City of Portland, Maine - Building or Use Permit Application

Permit No: 06-0078	Issue Date: MAR 6 2006	CBL: 037 F022001
Owner Address: 477 Congress St		Phone: 2076532341
Contractor Address: So. Portland		Phone: 2076532341

Past Use: Commercial	Proposed Use: Commercial Change of Use: Photography Studio to a Fitness Wellness Center. (2nd floor)	Permit Fee: \$366.00	Cost of Work: \$30,000.00	CEO District: 1
Proposed Project Description: Change of Use : Photography Studio to a Fitness Wellness Center (2nd floor)		FIRE DEPT: <input checked="" type="checkbox"/> Approved <input type="checkbox"/> Denied	INSPECTION: Use Group: Type: B 3/3/06

MEZZAanine FITNESS
 1/8" = 1' 0"
 15 FEB '06

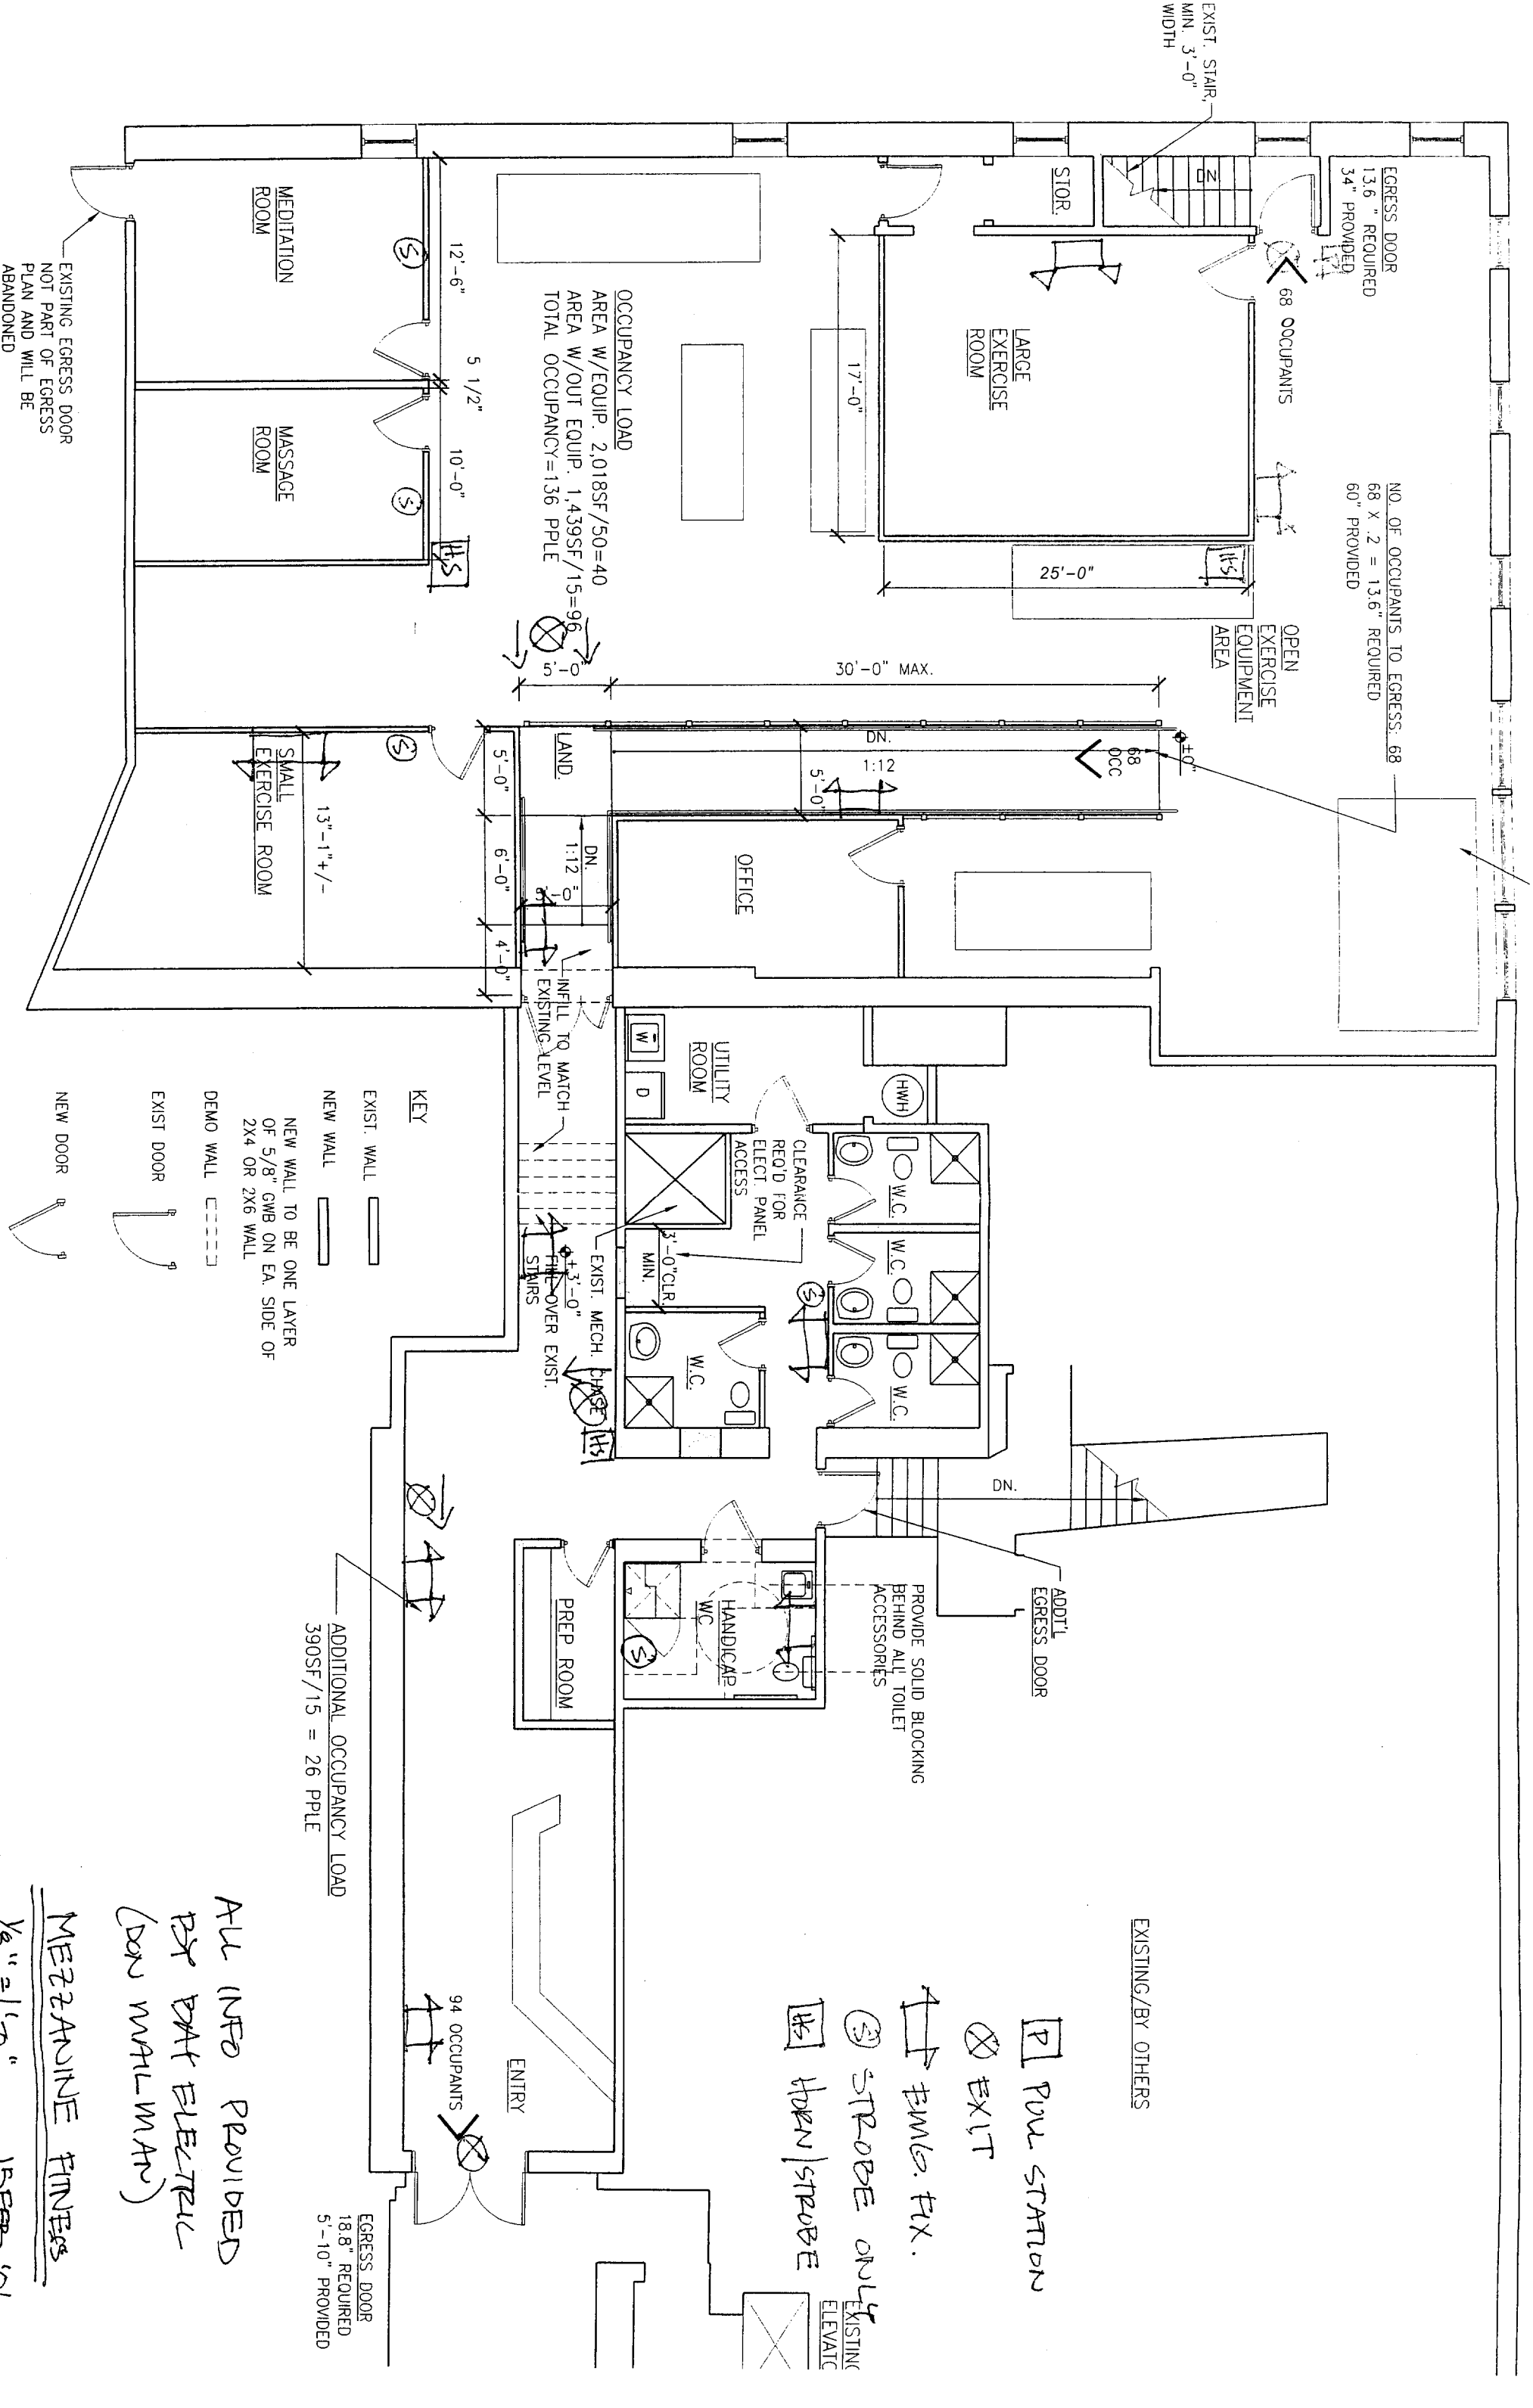
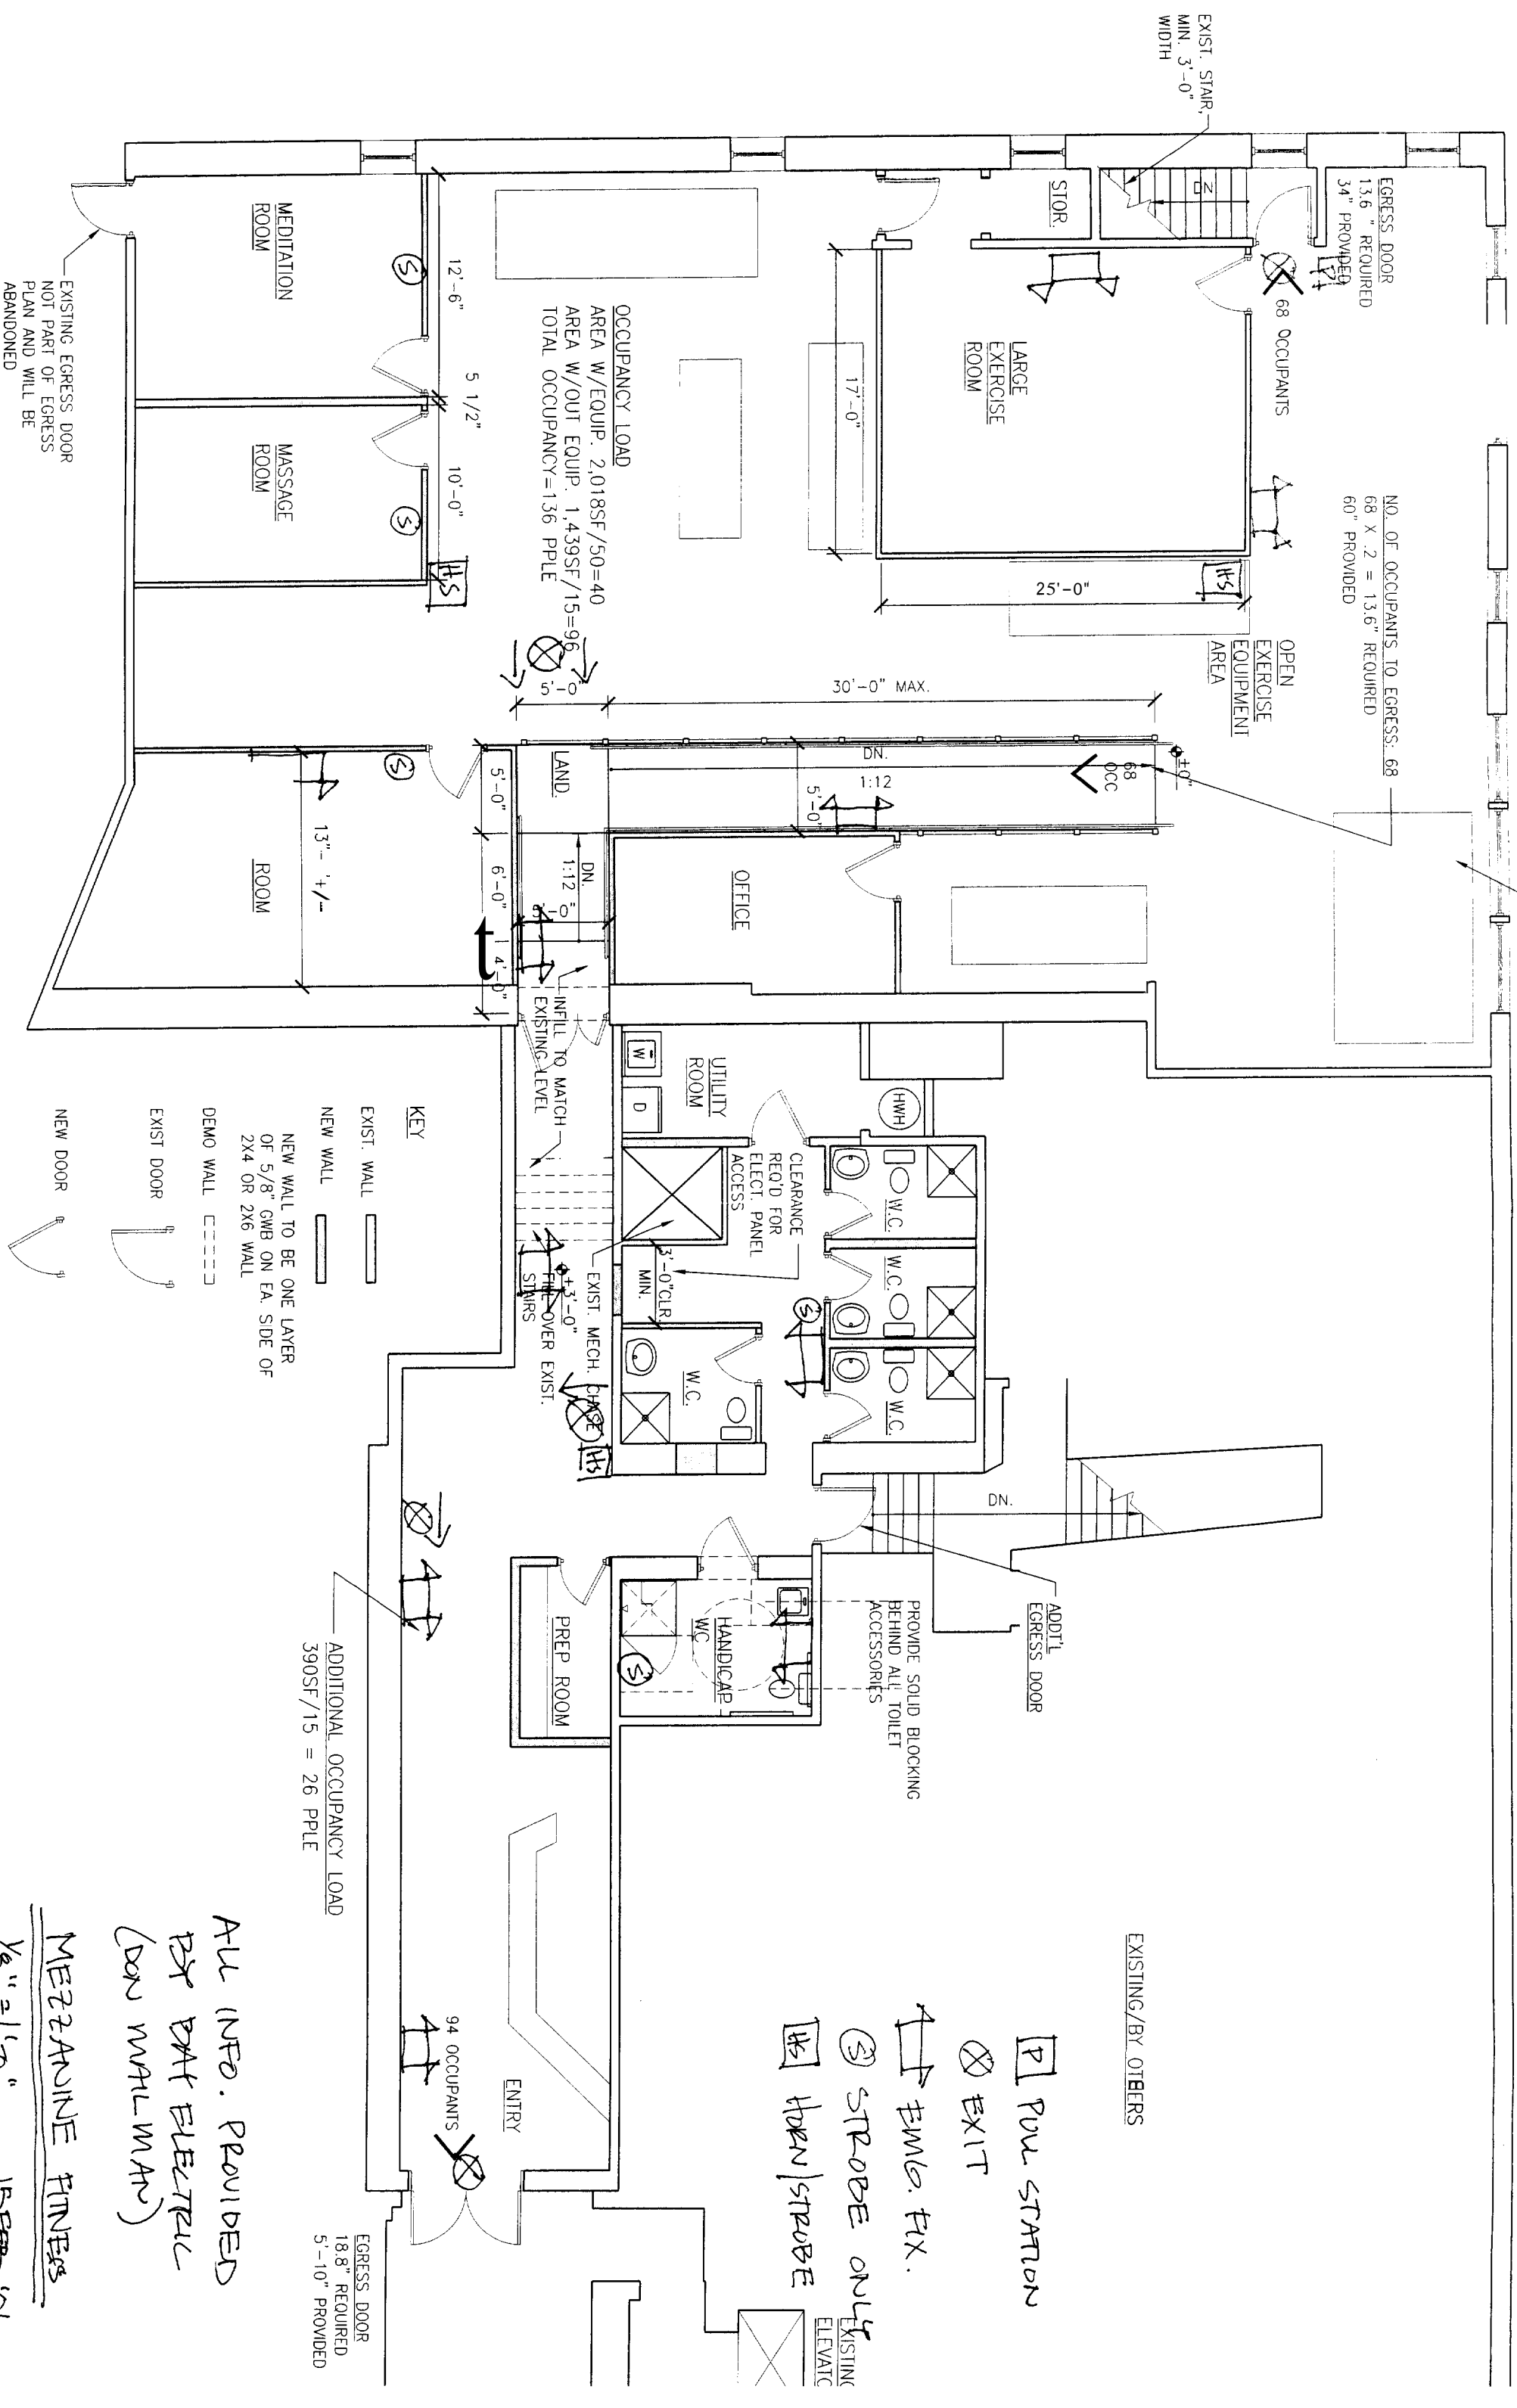
- 1) Fire Alarm and Sprinkler contractors are to be consulted before the addition or removal of any walls.
- 2) A LifeSafety Plan shall be submitted Showing compliance with NFPA 101.

**2** PLAN DETAIL – RAMP  
1/4"=1'-0"

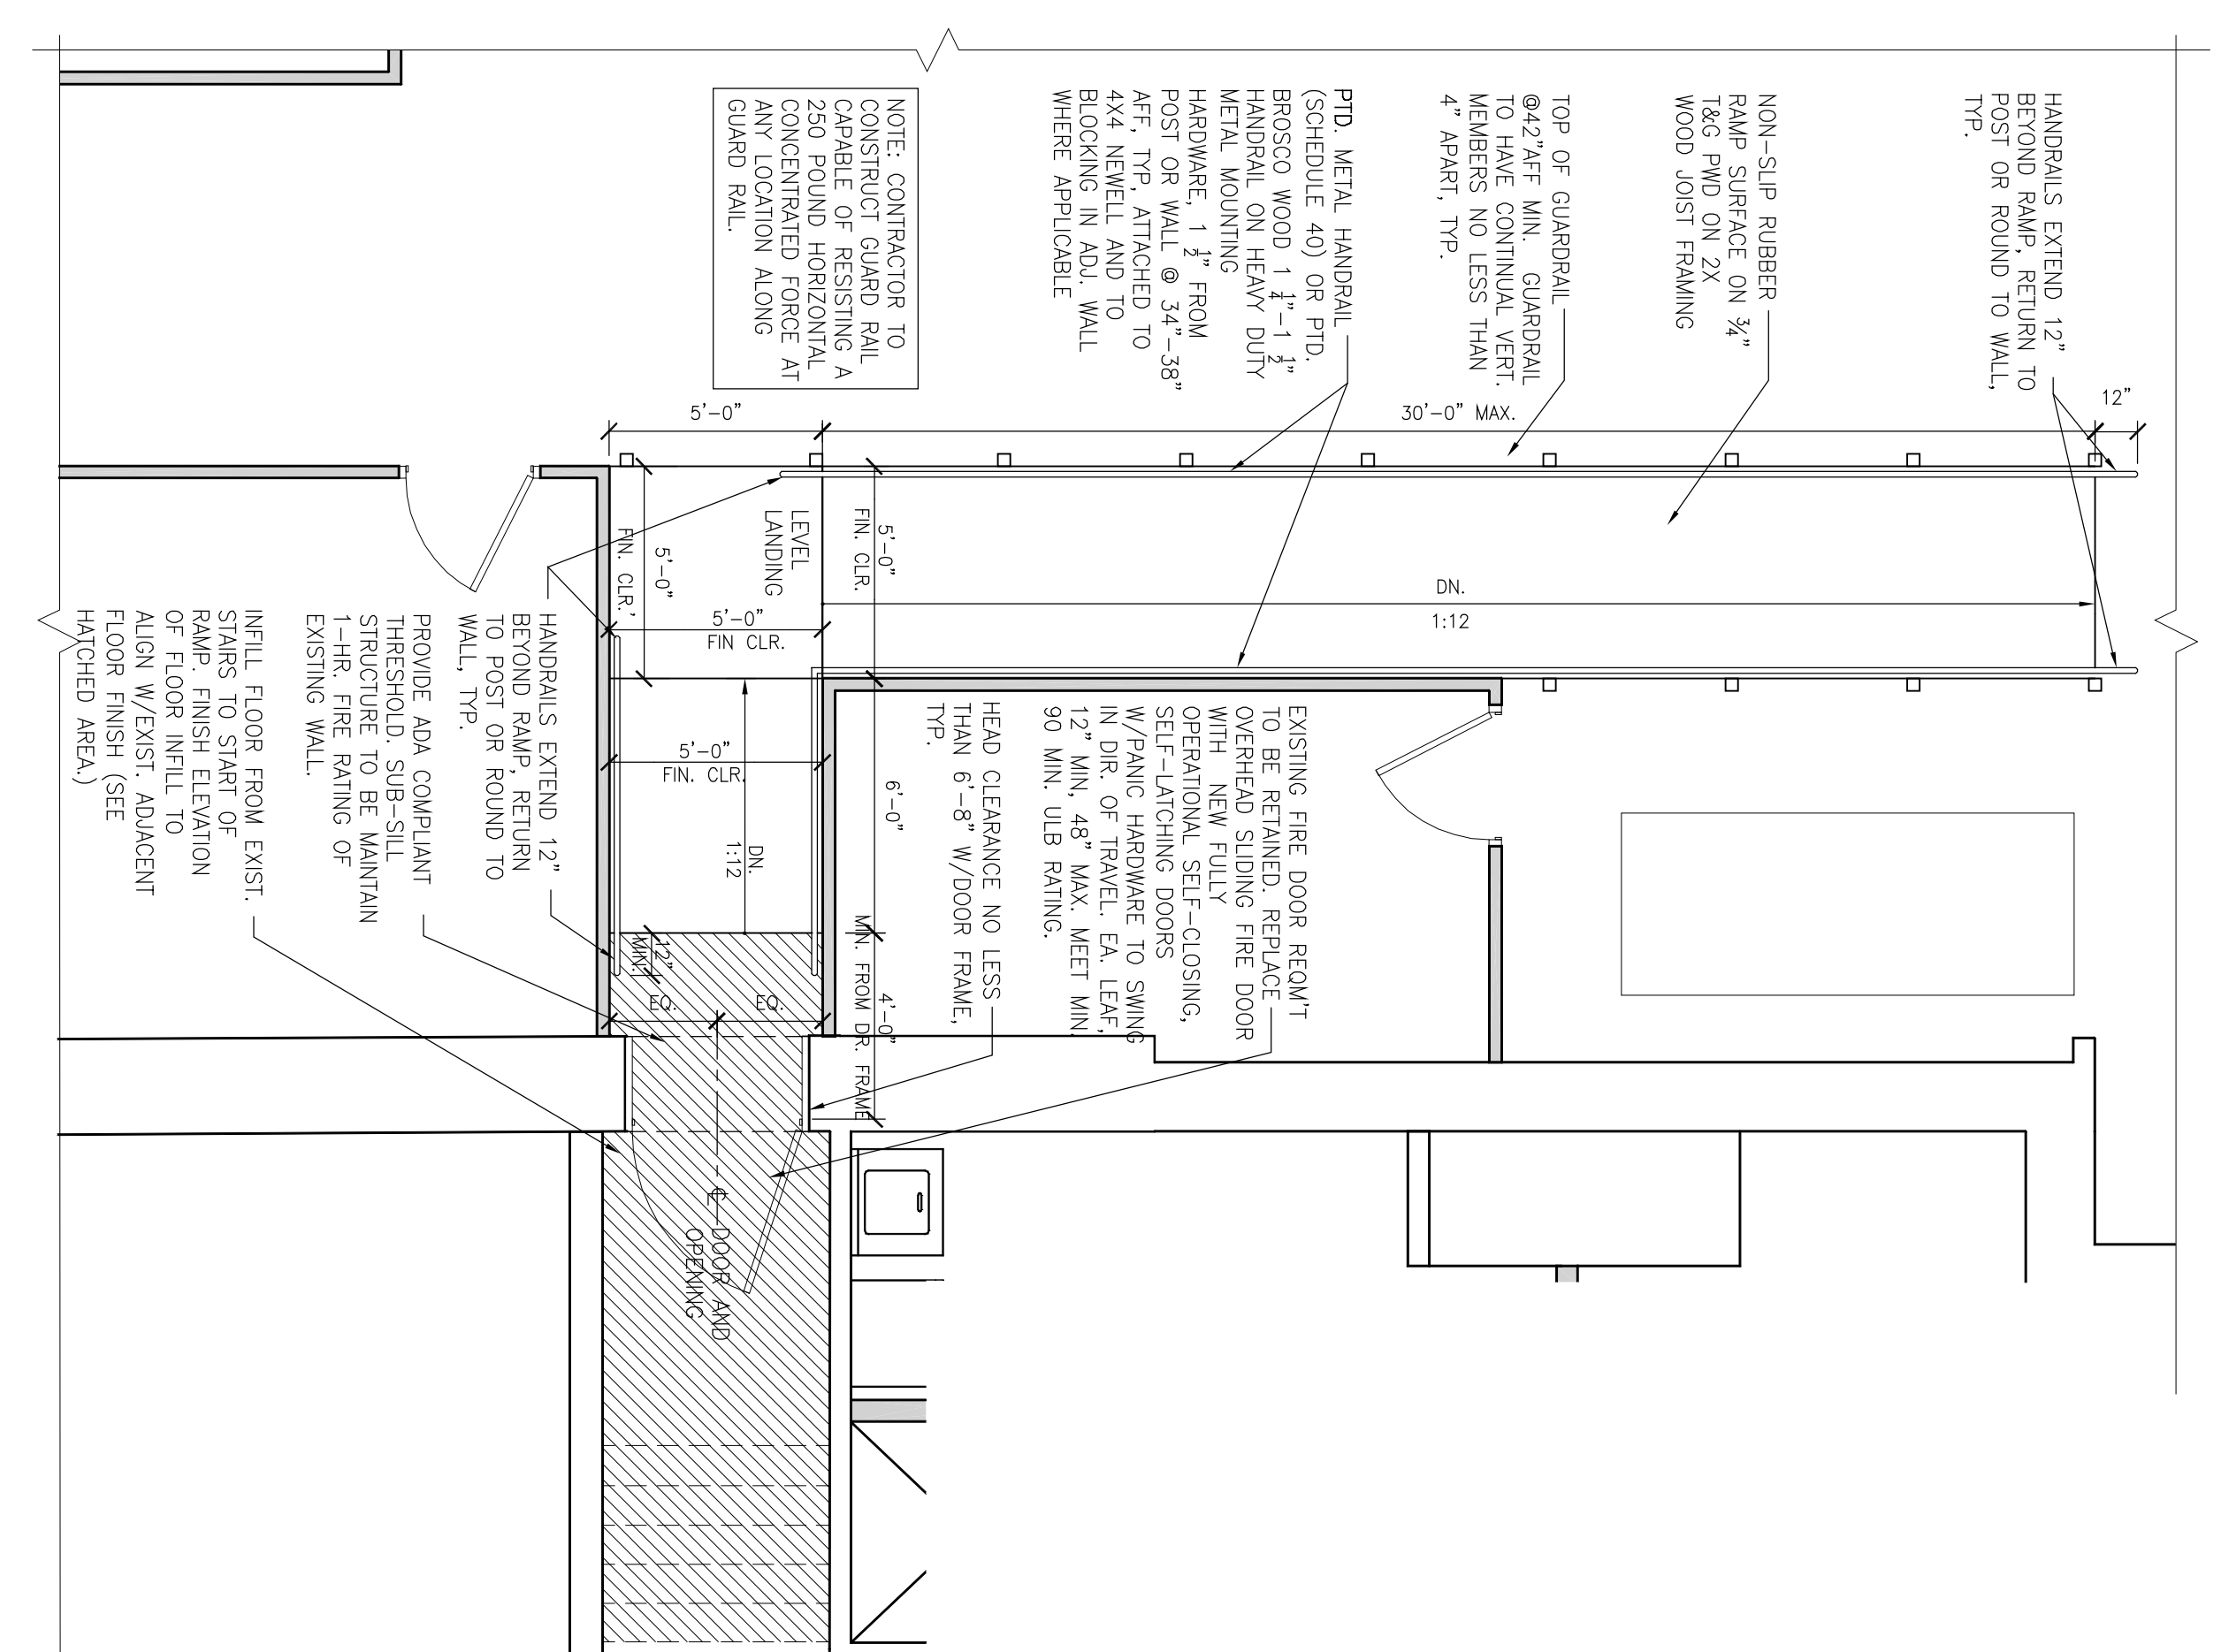
- 1) This permit does not include the rampo construction, as code details need to be worked out prior to commencement of ramp construction.
